Harnett County Government Complex
307 Cornelius Harnett Boulevard
Lillington, NC 27546

**Re: Status of Improvement Permit Application #07-5-18839
Woodshire Lt 164**

SURVEY FOR:
PROPOSED PLOT PLAN - LOT - 164
WOODSHIRE S/D, PHASE - 5

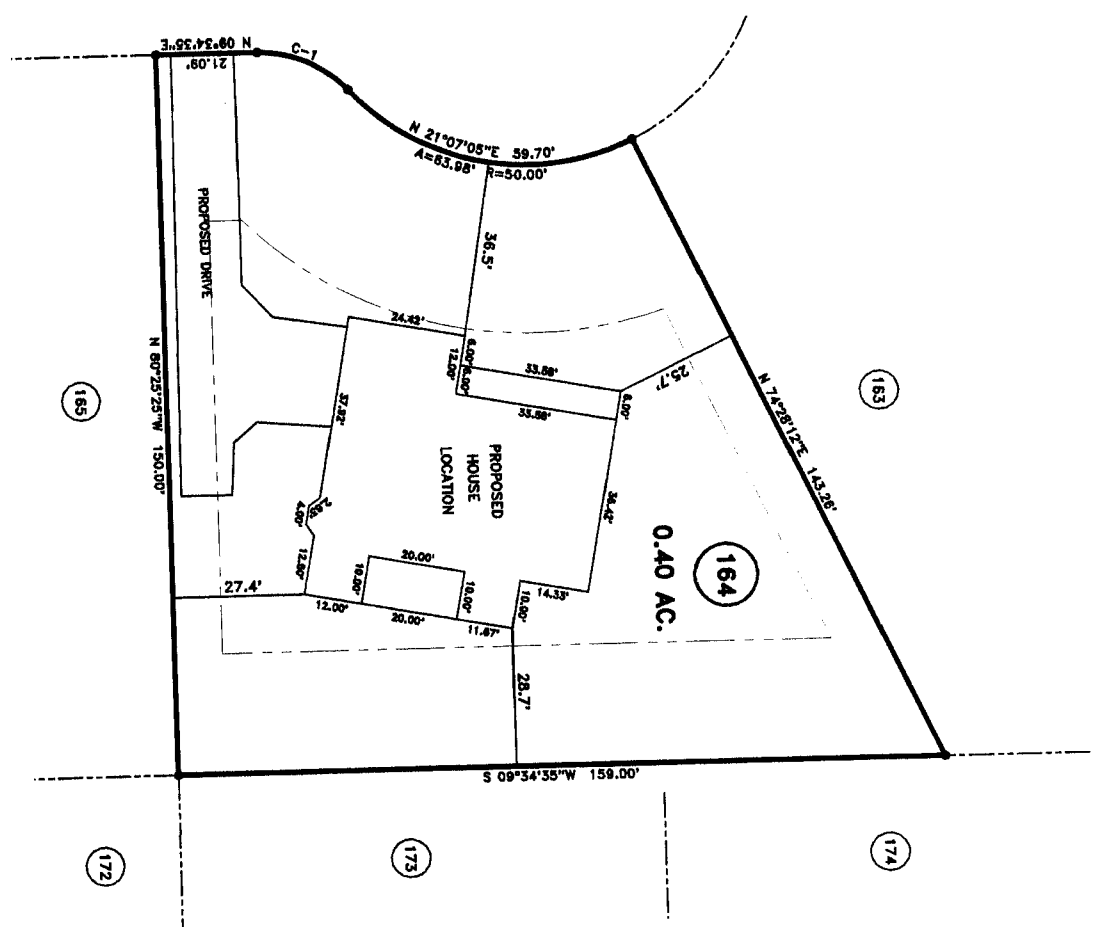
Due to house size (footprint and number of bedrooms), lot size, and home location on the lot, a permit can not be issued. You need to reduce house size (footprint and number of bedrooms) and place home on lot so that there is area available for septic system and repair.
